Your Ref: 100654436-002  
Our Ref: 23/03464/LBC

Date 19th December 2023

**Application No:** 23/03464/LBC  
**Proposal:** Listed building consent for internal works to office building  
**Address:** City Chambers Kirkgate Dunfermline Fife KY12 7ND

Location Plan 1:1250

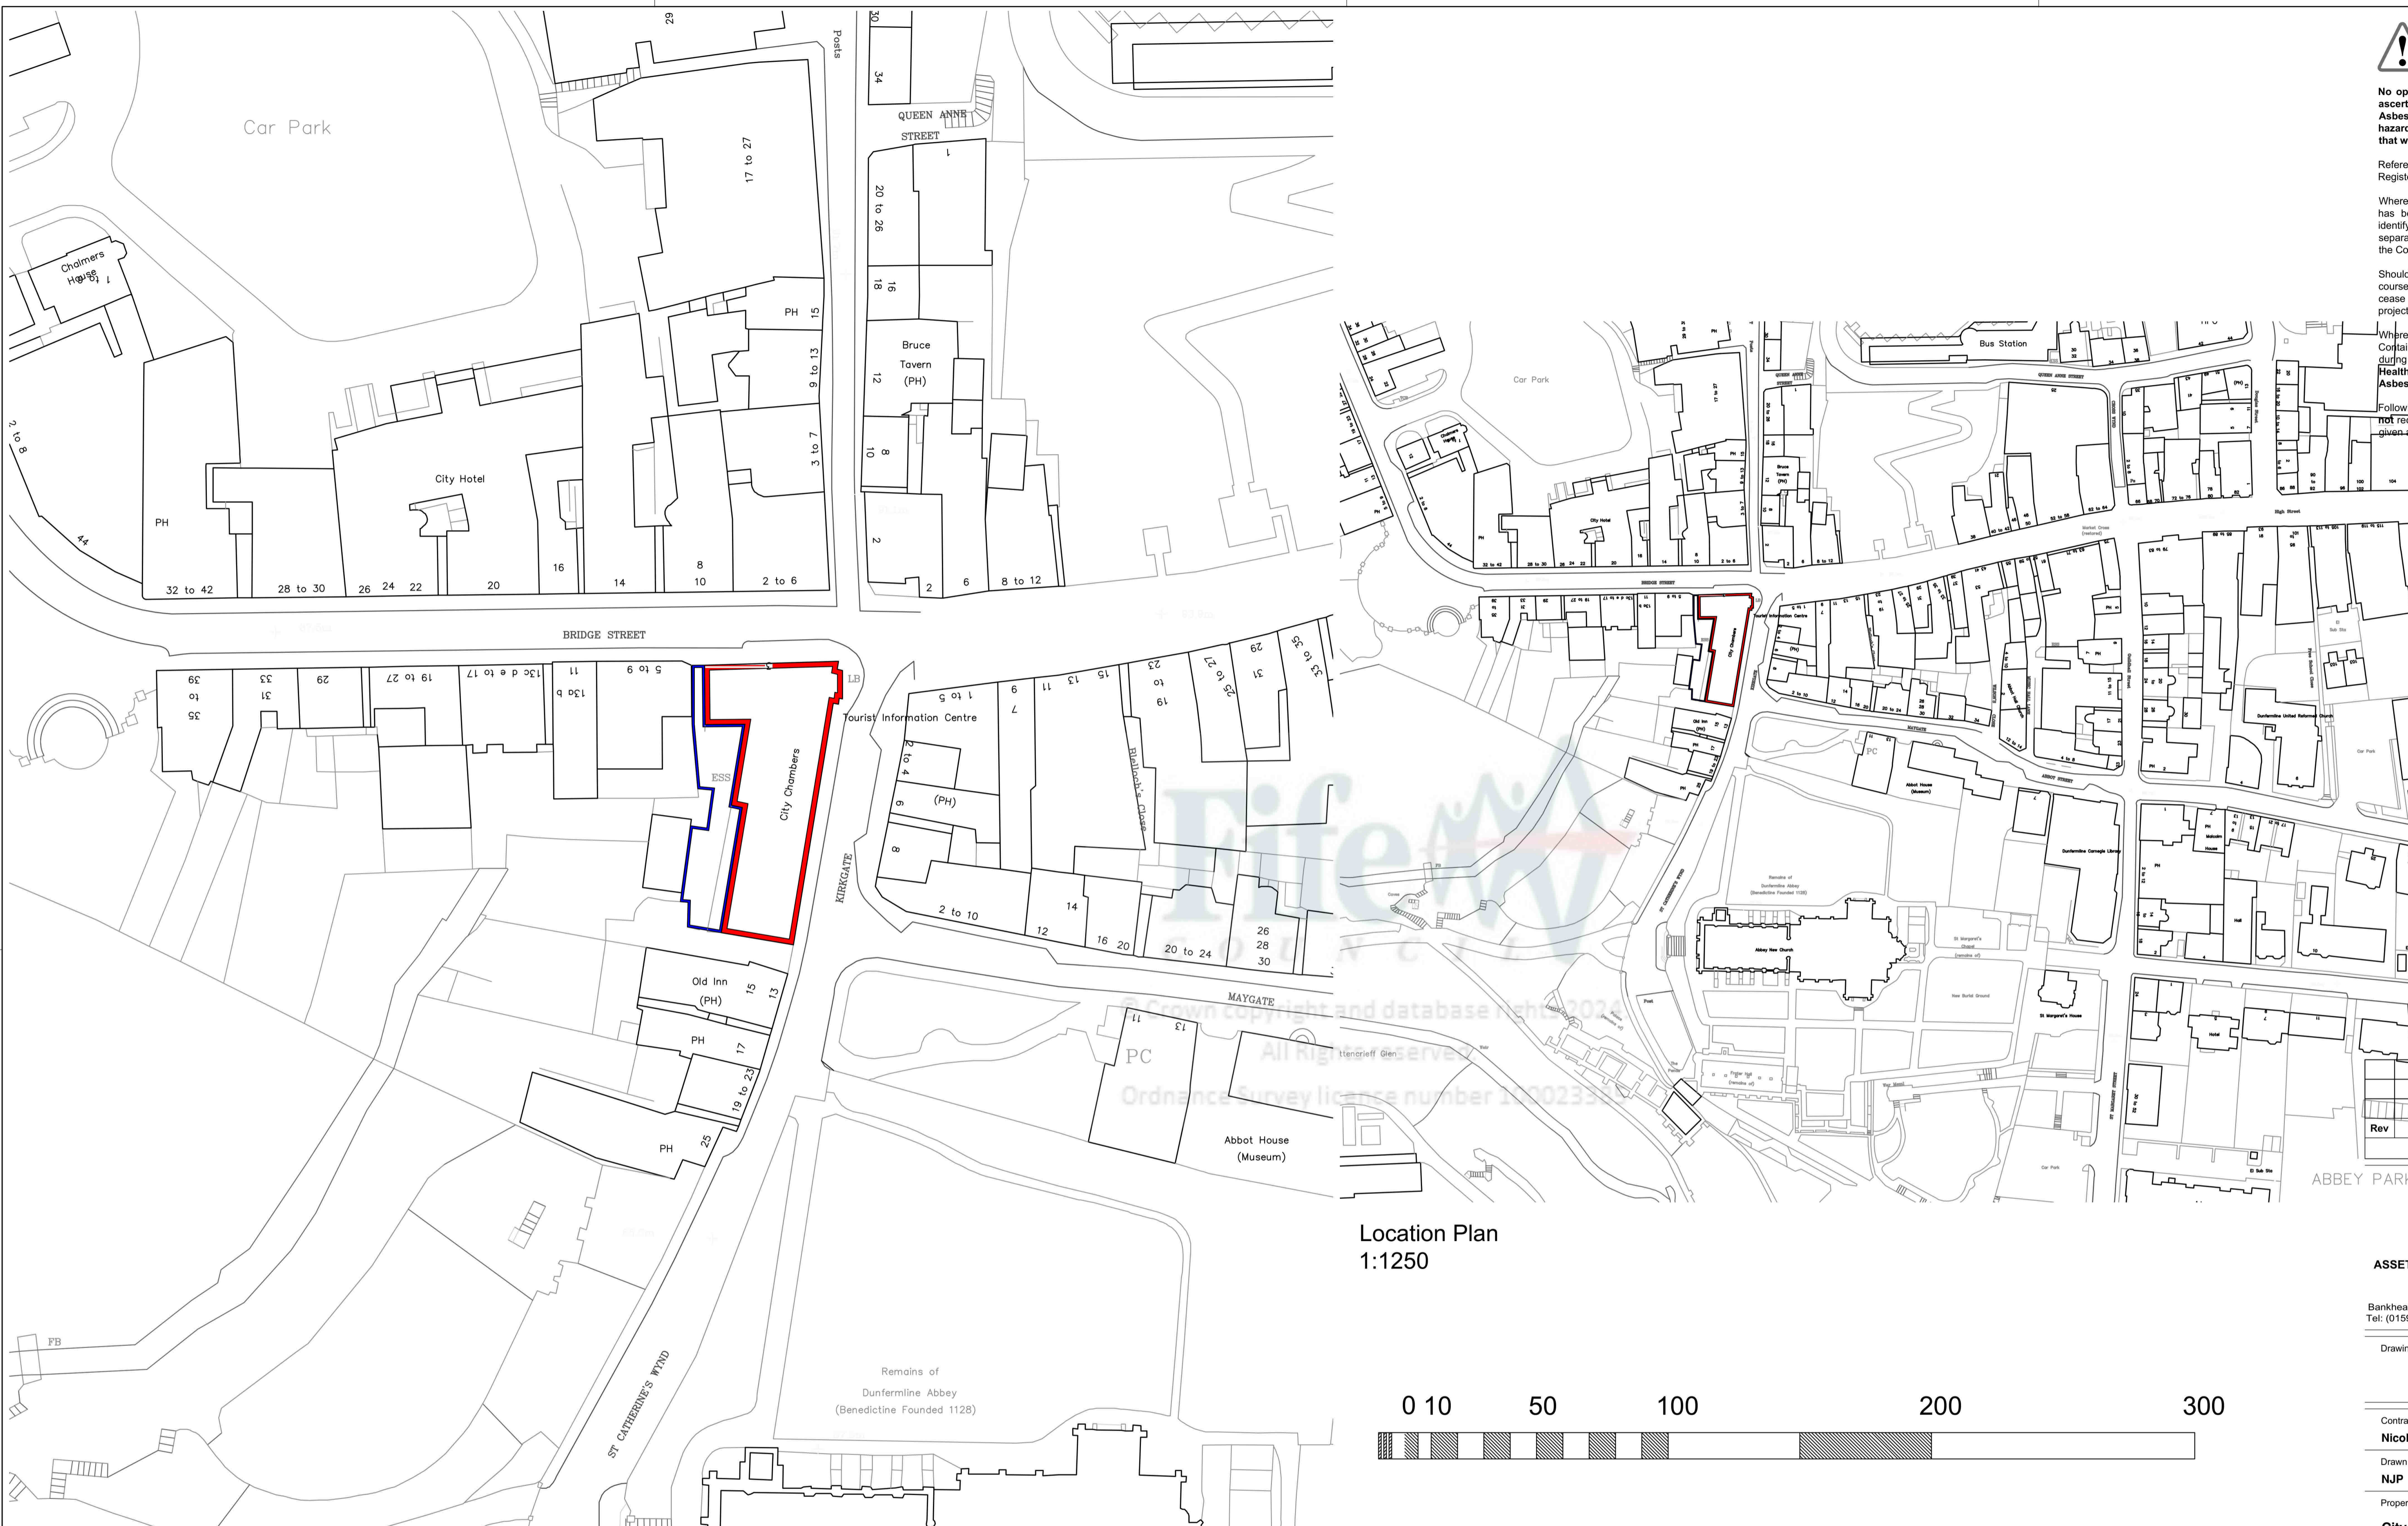
1. You have not submitted a valid location plan. Please submit a location plan to a scale of 1:2500 or 1:1250 with the boundary of the site to be developed clearly outlined in only one continuous red line showing a north point and at least two named roads and surrounding buildings. We cannot accept the colour red on any other parts of the location plan and/or multiple red lines.
2. You have not submitted a valid block plan. Please provide a block plan to a scale of not less than 1:500; with the site boundary clearly outlined in only one continuous red line to match the location plan and showing a north point.
3. Your existing and proposed floor plans did not contain a scale bar to allow the drawings to be calibrated. Please submit replacement plans with an accurate scale bar annotated.
